Re: Five Estuaries Offshore Wind Farm – Request for Further Information Under Rule 17 of the Infrastructure Planning (Examination Procedure) Rules 2010 (as amended)

Thank you for your letter dated 13 December, requesting an update regarding Harwich Haven Authority's (HHA) views on the Five Estuaries Offshore Wind Farm project in relation to the specific questions outlined in ExQ2 [PD-014], Reference NS.2.01.

DRAWING NUMBER: 3.1

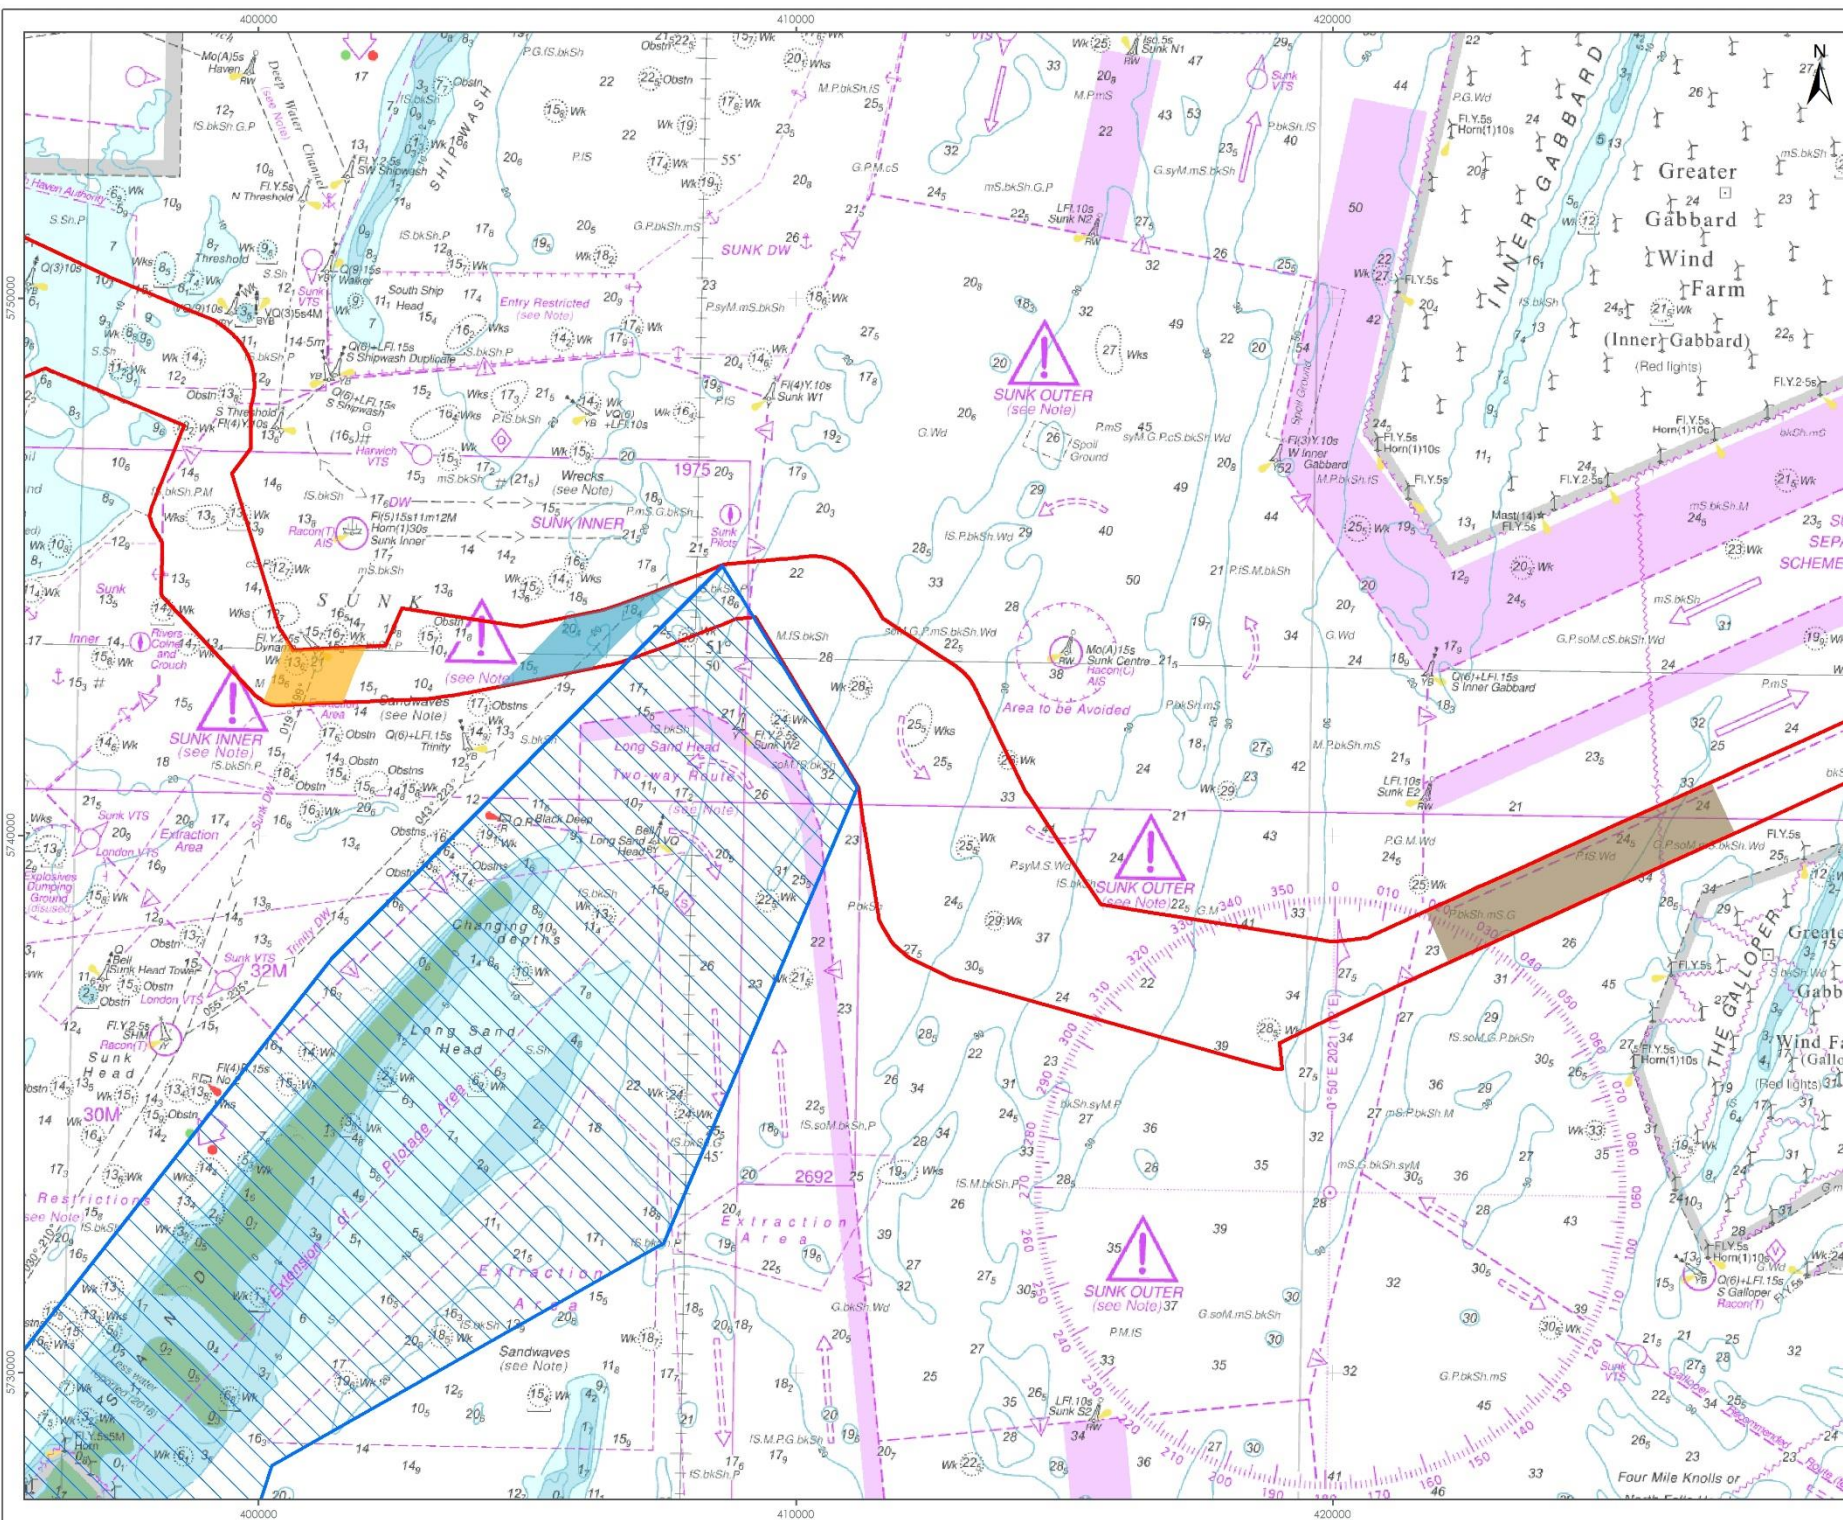
- Requiring protective measures within the DCO to ensure that the cable route is at a suitable depth to ensure future deep draught vessels can navigate the Sunk area. The cable (and any covering material e.g. rock armour) must be at least 22 metres below Chart Datum to allow future vessels with a draught of 20 metres.

- Exclusion zone(s) must not be put in place in the Sunk area or channel that would restrict 24/7/365 vessel access requirements or pilot boarding operations etc.
